September 22, 2010

Vincentia Ratepayers and Residents Association Submission to NSW Department of Planning Major Project Application MP 06_0205 Modification No 2

Department of Planning Reference: MP06_0205 (Mod 2)

Appendix D – Sketch of Options

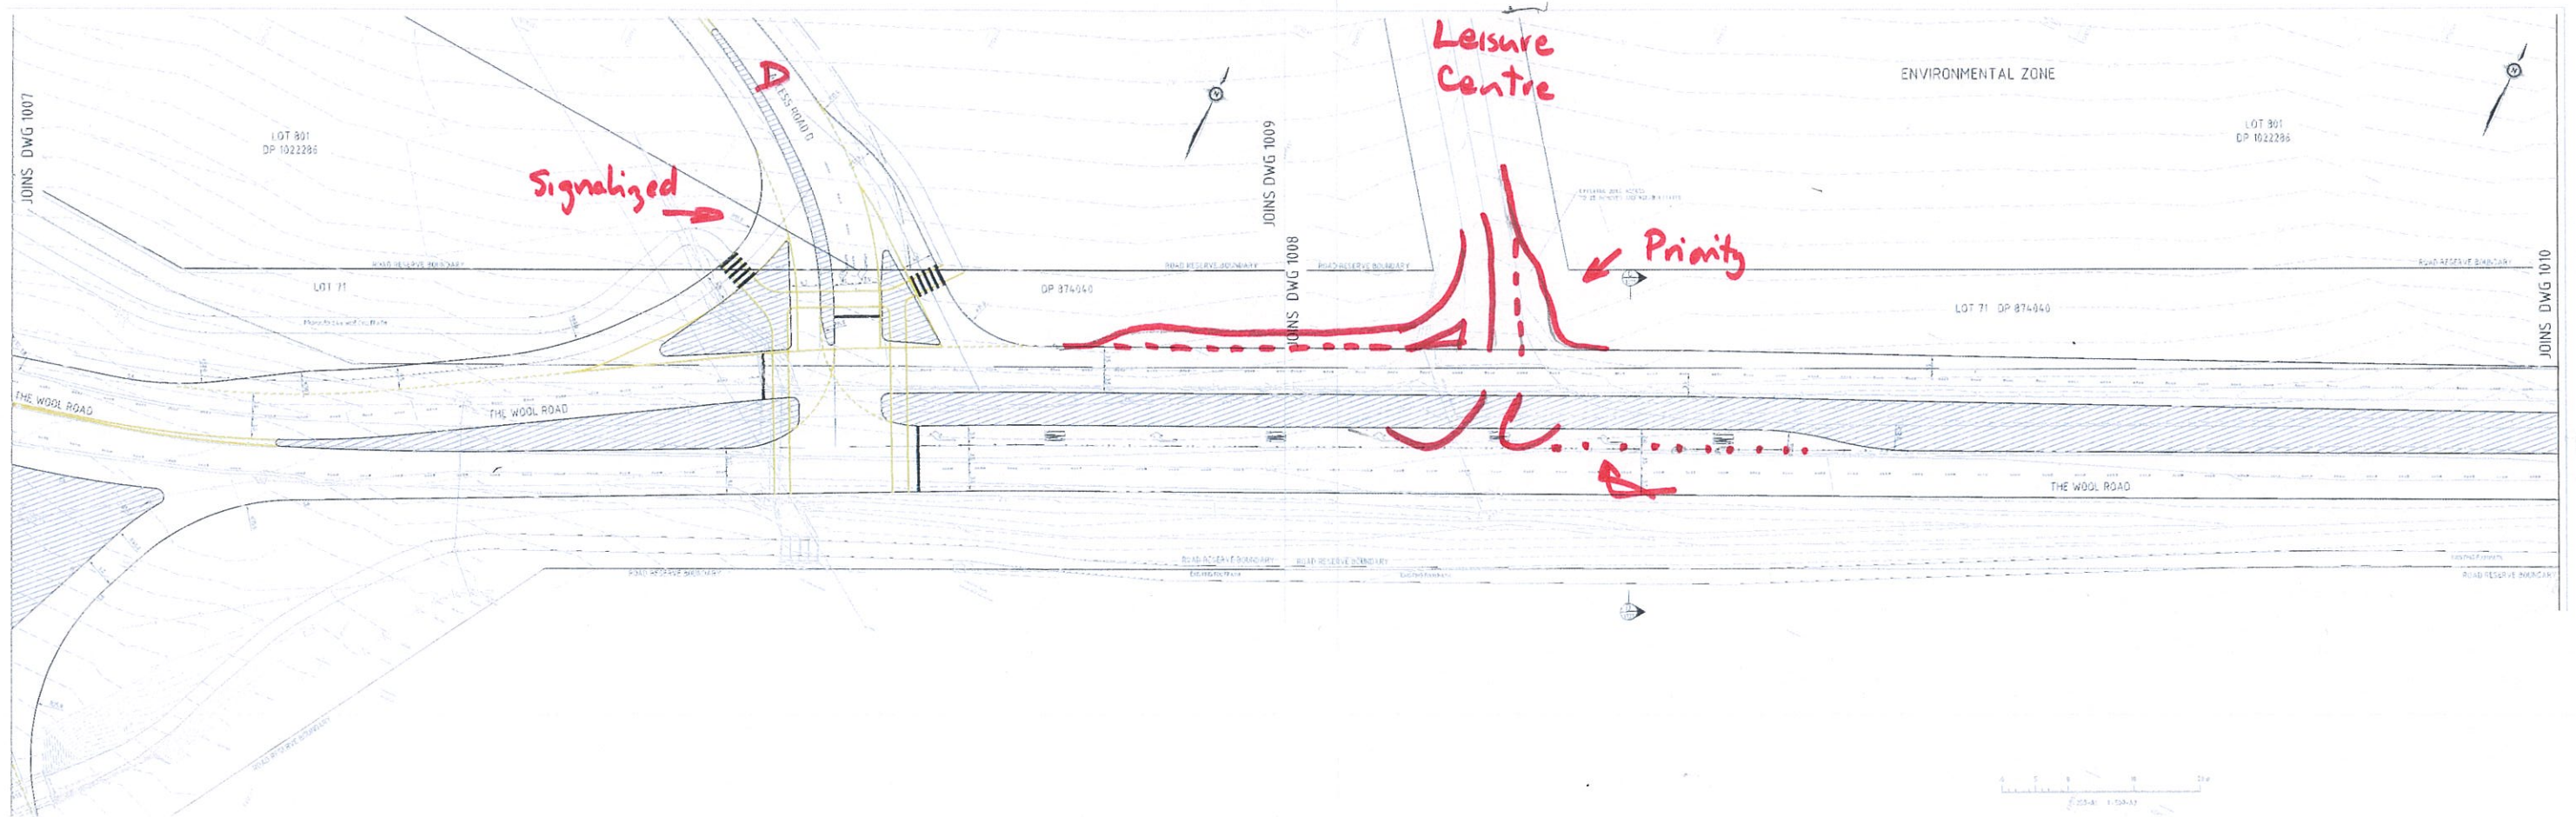
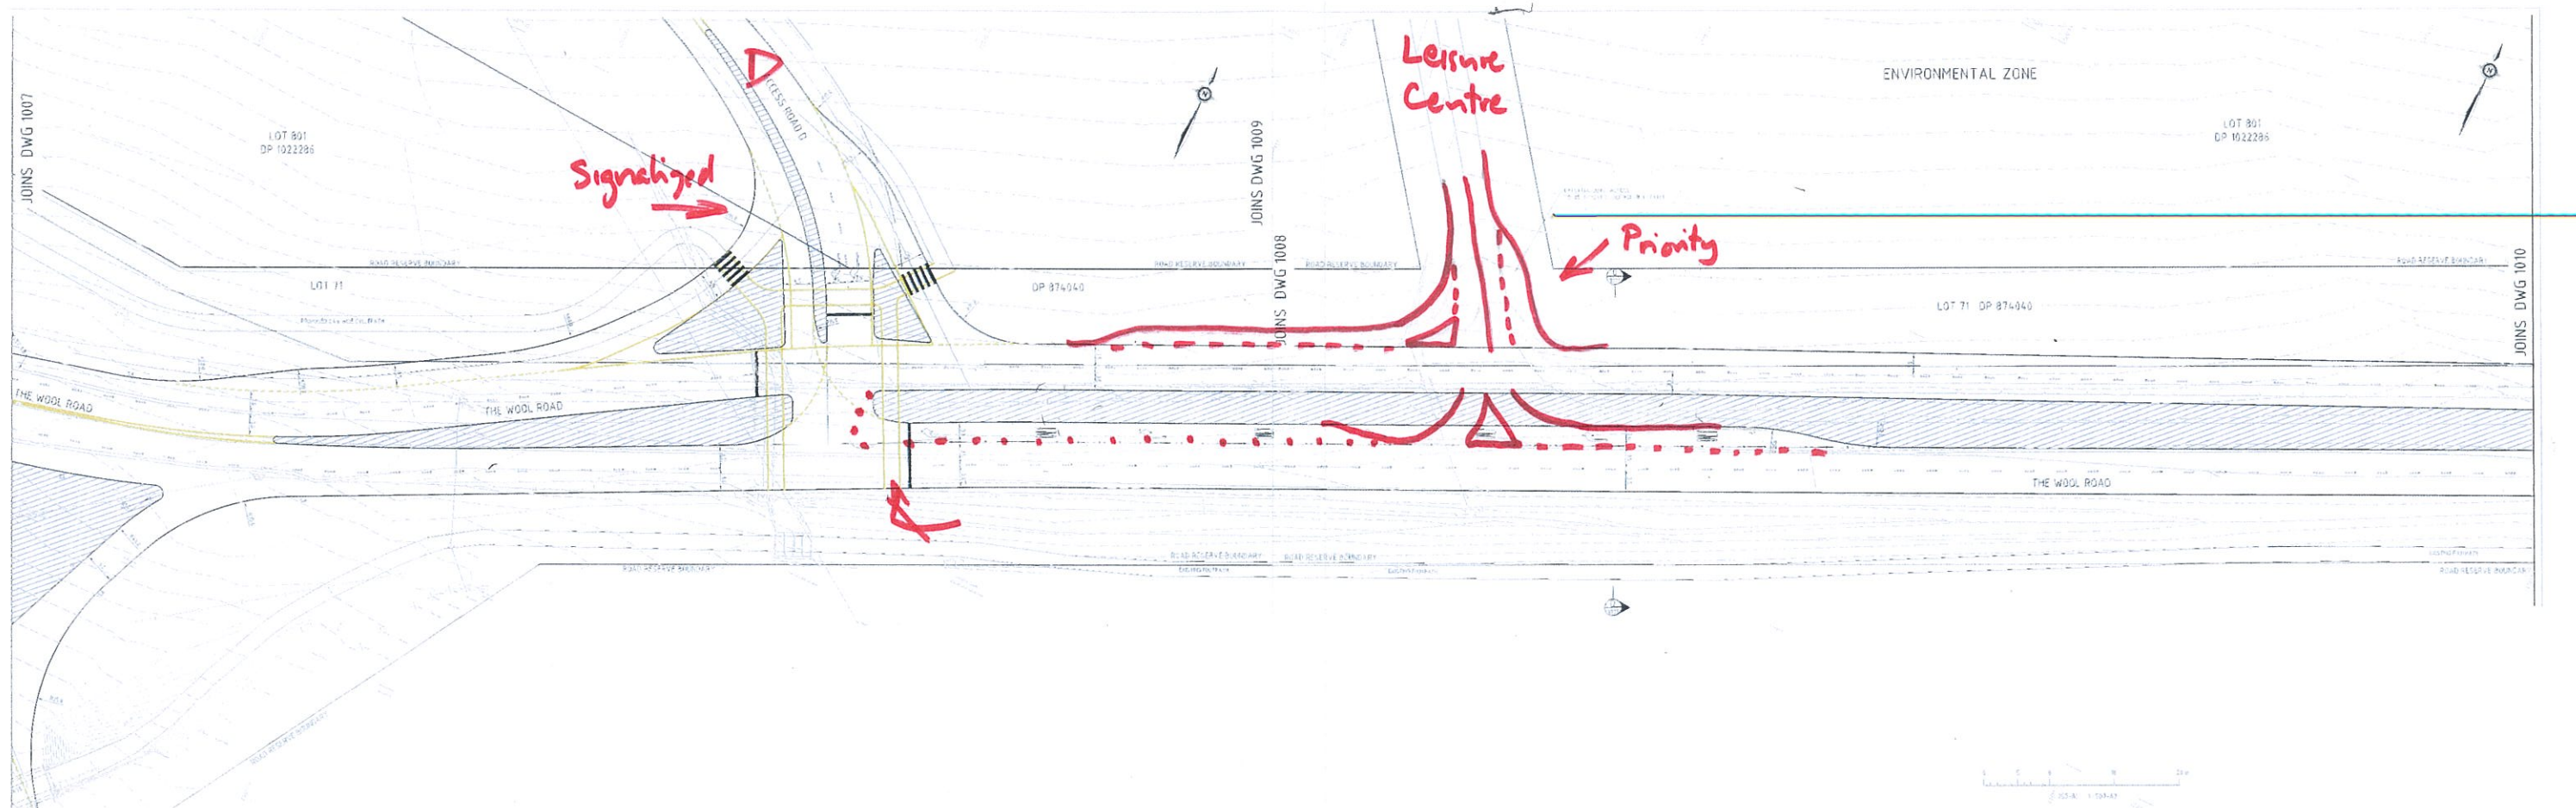
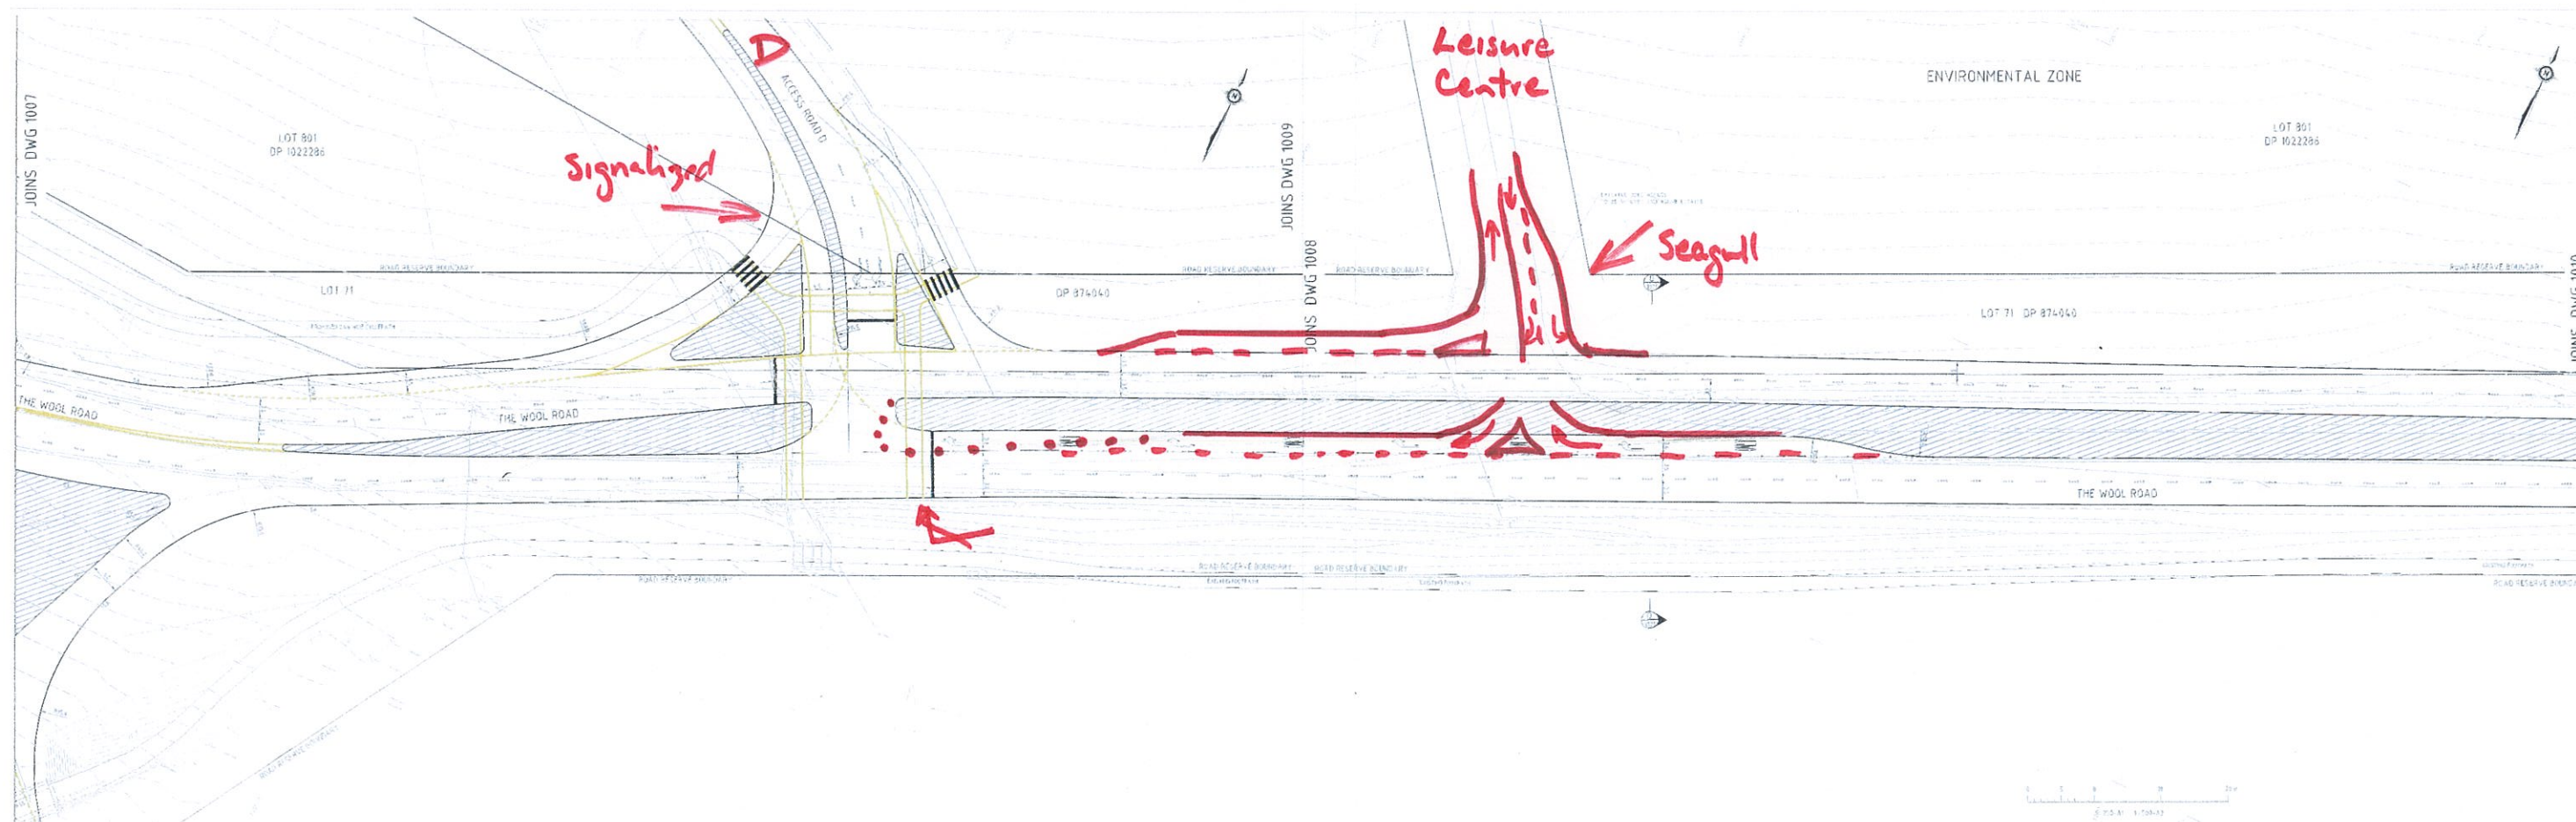
1. **The proposed access roads to the centre** – we believe that the most practical plan for access off The Wool Road is to use the position of the current road which leads to the Leisure Centre with a T intersection where the road turns to the right at present. There would be a road to the left leading to the VDC and a road to the right to the Leisure Centre and the playing fields. We do not believe that there is any need for two access roads and two sets of traffic lights within a few metres of each other. After all, there will be no increase in traffic to the Leisure Centre as result of the VDC.

We understand the question of access to and from Wool Road is being negotiated between the parties as we write. However, our view remains that there should only be one set of traffic lights on Wool Road and Woolworths' proposed access is too near the roundabout. We believe a cycleway/footpath on the northern side of Wool Road between the VDC and BBLC is essential for safety.
